RE: 6/2022/2801/MAJ

Sat 14 January 2023, Welwyn Garden City

I'm writing to express my concerns related to the above planning application. The proposed development plans to build 313 dwellings in several multi-storey flat blocks that are of much larger scale than the surrounding buildings. The number of dwellings is too much for the allocated space and highly disruptive to the town appearance. Specifically:

Figure 5.3: Proposed development sections. Source: Architect's DAS.

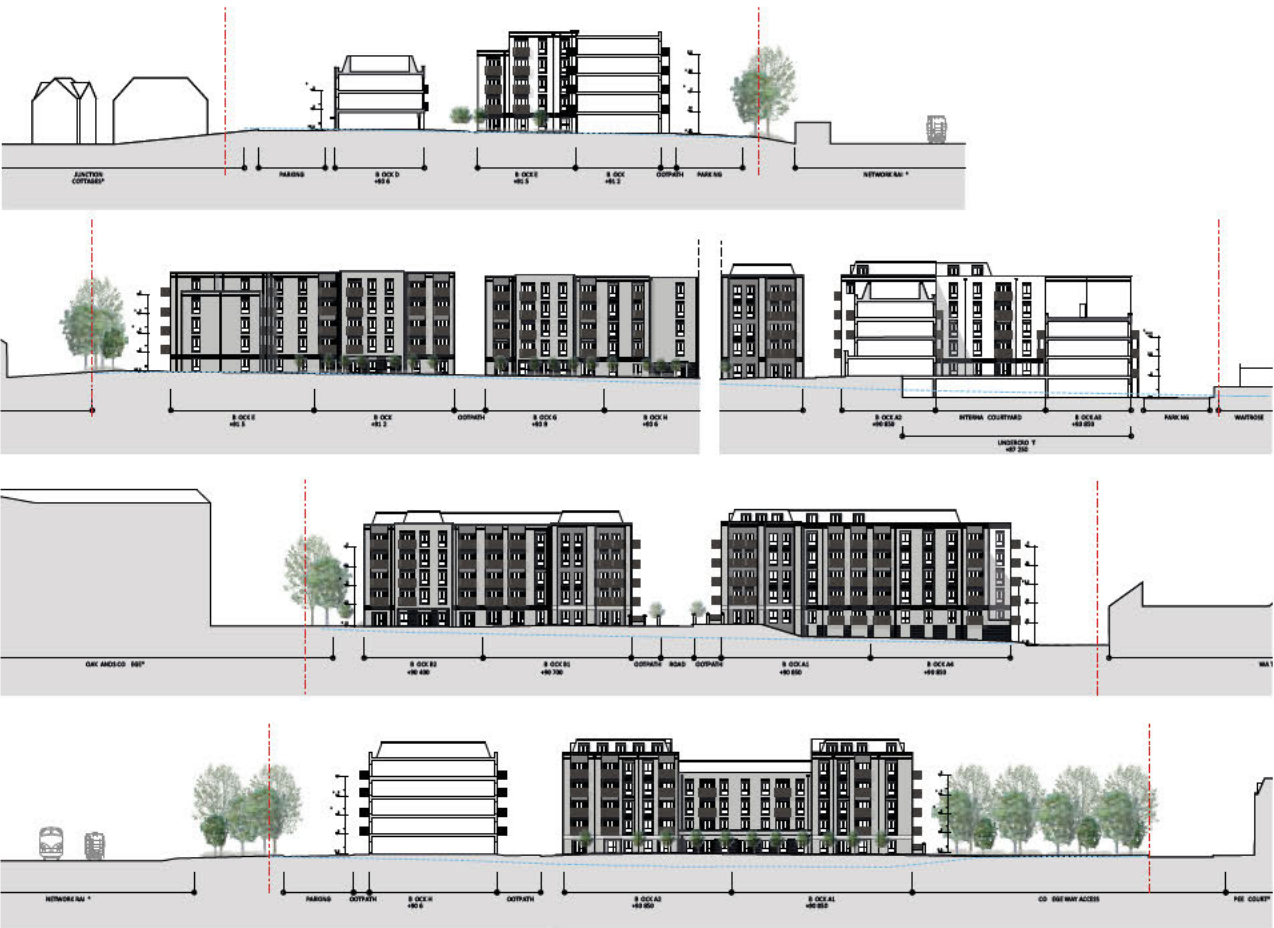
- Viewing the proposal in context of existing residential dwellings as well as other buildings nearby, the proposal aims to roughly double the height of buildings (up to five storeys) compared to existing surrounding buildings. This is very clearly visualised in the PDF of proposed site sections. Section A, C and E highlight the significant increase in height compared to the residential dwellings at Gresley Close, Blakemere Road and Walden Road as well as Oakland College and Waitrose. The pamphlet that Bellway sent to local residents also clearly highlights the height and size of the proposed blocks of flats. The image provides an illustration of the proposed green in the middle of the blocks of flats and it is clear from the illustration that the actual green will be overshadowed by the buildings. The size of the proposed blocks of flats seems out of proportion compared to its surroundings, will overshadow and diminish the impact of the proposed green landscaping and will be a dominant presence.

FIG 53 - CYCLE PARKING STRATEGY

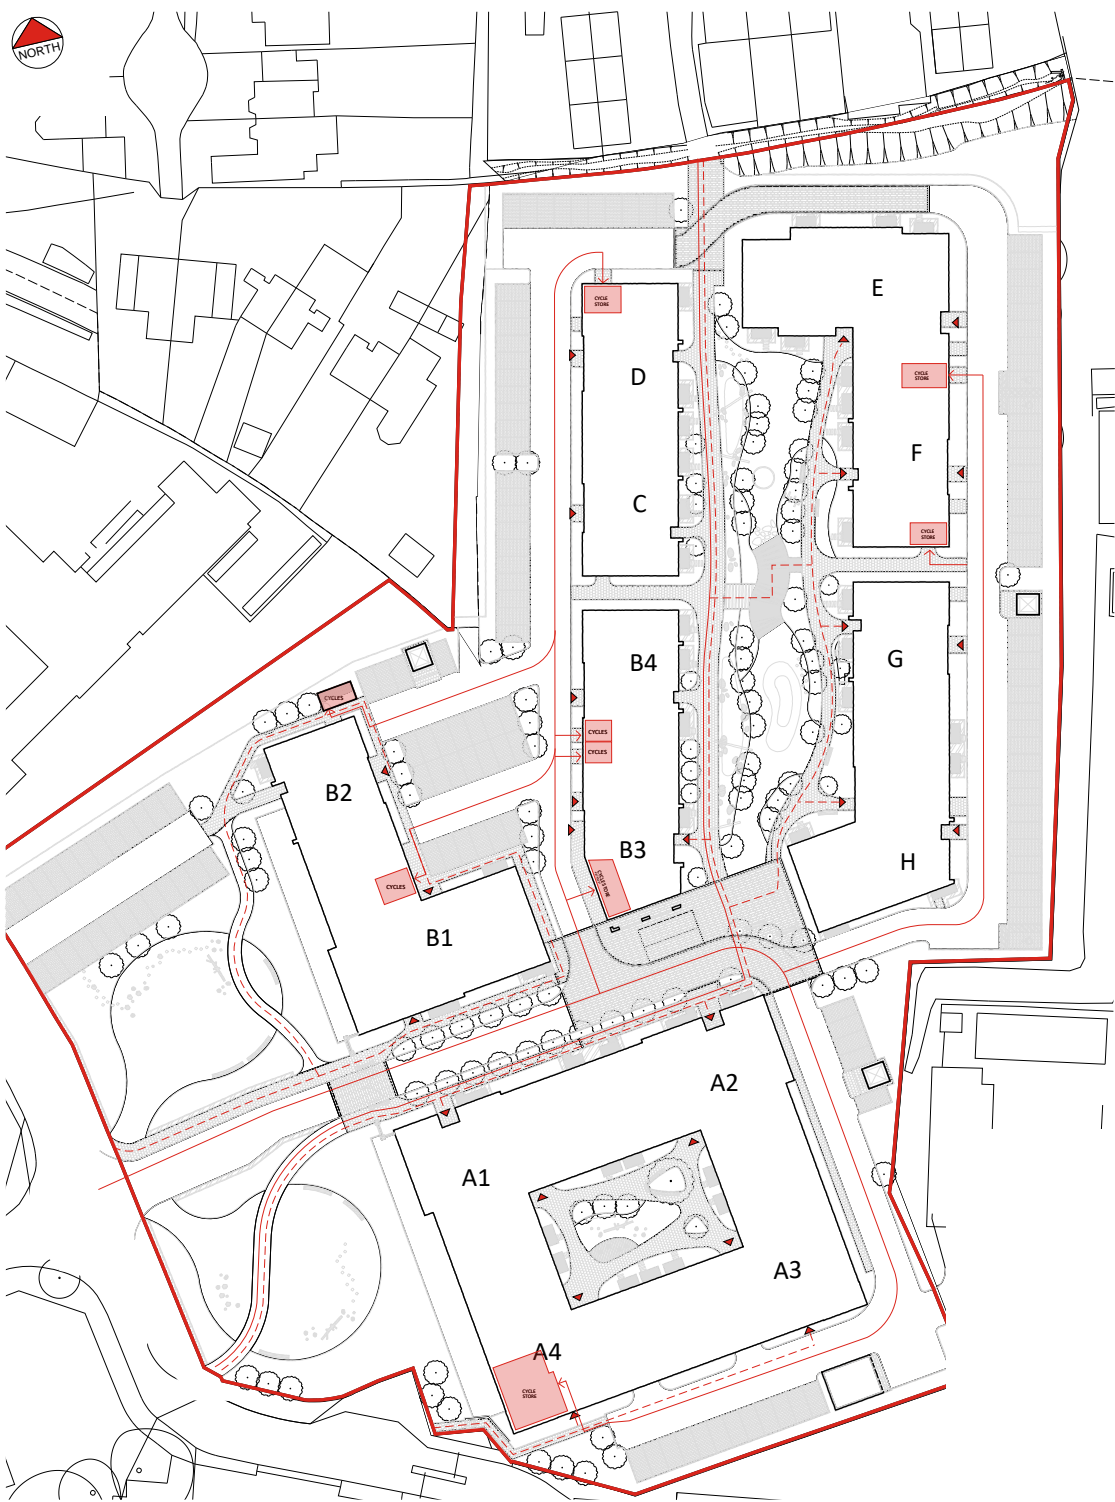
- The sheer number of dwellings does not seem adequately supported by travel plan or parking allocation. It may be commendable to create one cycle storage space per dwelling, but highly unrealistic. I do not think that existing Welwyn Garden City flats currently have on average one cycle per dwelling and do not think this is a realistic expectation. And if this is realistic, there no provision for cycle paths in the proposal. Current drawings suggest that cyclists will share the pavement with pedestrians,

which I think it not a good way to promote cycling. Conversely, the number of parking spaces is set at 0.58 per one and two bed flat, which is proposed to be adequate compared to the quoted average of 0.42 in the surrounding area. The source of the 0.42 average is not provided, but this number does not seem to add up to data quoted by NimbleFins (<https://www.nimblefins.co.uk/cheap-car-insurance/average-cost-run-car-uk>) that the number of cars per household in the UK is estimated to at 1.18 (higher if London is excluded). Furthermore, the Welwyn Garden City Local Plan quotes that the 2011 census estimated that 79% of households in Hertfordshire have access to at least one car or van and the Local Plan also suggests that zones 1-2 in which the proposal falls could have 0.75 cars per one bed flat, 1 car per two bed flat and 1.5 cars per 3 bed flat. Acknowledging that the Local Plan does not provide a maximum or minimum, calculating the car density based on the above would suggest that up to 291 parking spaces (0.93 per dwelling) may be needed, which is 60% higher than the number accounted for in the proposal. The provision of 0.58 parking spaces per dwelling is not sufficient and reducing the number of dwellings will give a more balanced development that can deliver on a realistic travel plan.
